Planning Department Alan Varela, Director

August 22, 2025

Re: Primrose School 4550 Paradise Blvd. NW Traffic Circulation Layout Engineer's Stamp 05-22-18 (C13-D029) TRANS-2025-00228

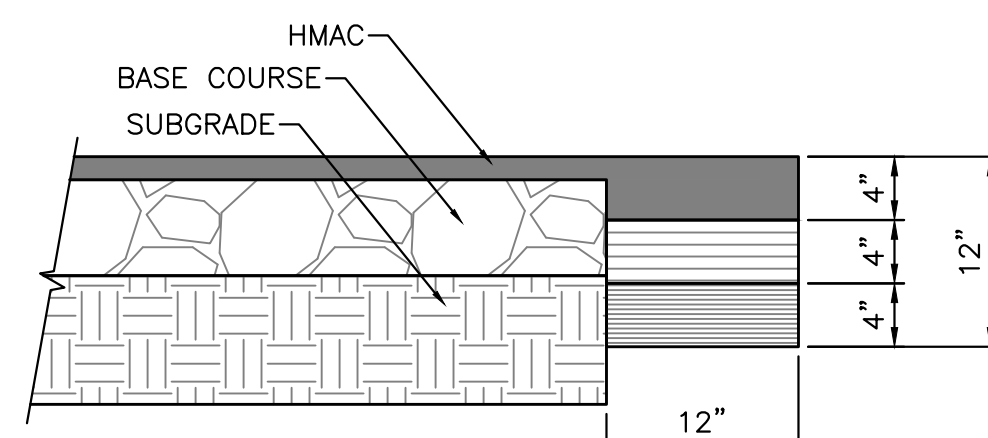
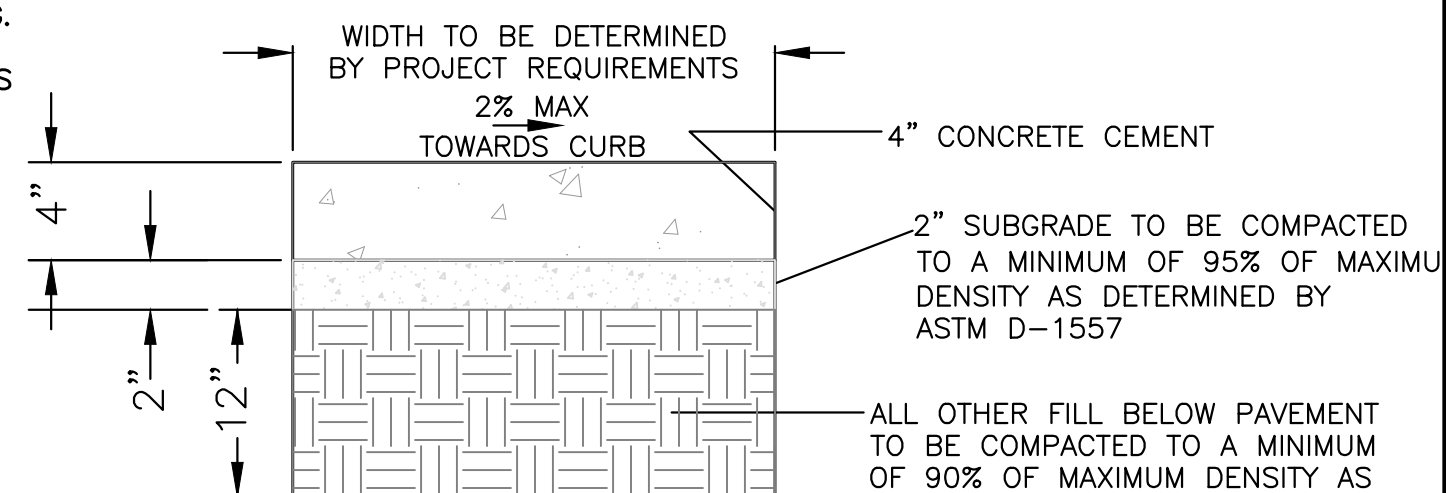
- 1. Please provide approve plat showing sheard access and shared parking agreements.
- 2. Please clarify, what is this shade area?

3. Please show on the site plan how wide is this pathway.

- 4. Please provide details sheet showing:
 - Interior ADA ramps' details.
 - ADA signage.
 - Proposed Pavement marking.
 - Motorcycle signage.
- 5. Please provide Bike Rack details, and ensure to provide 4 ft distance between each rack.

- 6. The ADA accessible parking sign must have the required language per 66-7-352.4C NMSA 1978 "Violators Are Subject to a Fine and/or Towing." Please call out detail and location of signs.
- 7. The ADA access aisles shall have the words "NO PARKING" in capital letters, each of which shall be at least one foot high and at least two inches wide, placed at the rear of

- the parking space so as to be close to where an adjacent vehicle's rear tire would be placed. (66-1-4.1.B NMSA 1978)
- 8. Google street view shows existing wooden power poles. Please show their locations on the site plan and ensure they do not block site accesses, parking spaces and drive aisles.

- 9. Motorcycle parking spaces shall be designated by its own conspicuously posted upright sign, either free-standing or wall mounted per the zoning code.

- 10. The pavement marking "MC" should be shown in the opposite direction for motorcycles entering the parking space.
- 11. Refuse vehicle maneuvering shall be contained on-site. The refuse vehicle shall not back into the public right of way.; provide a copy of refuse approval.

- 12. Provide copy of Fire Marshal approval.
- 13. Please provide up to date TIS form signed by Transportation manager Ernest Armijo.
- 14. It is not apparent what type of pavement surface is being proposed. A hard driving surface will be required as part of this proposed project for parking area and drive aisles.
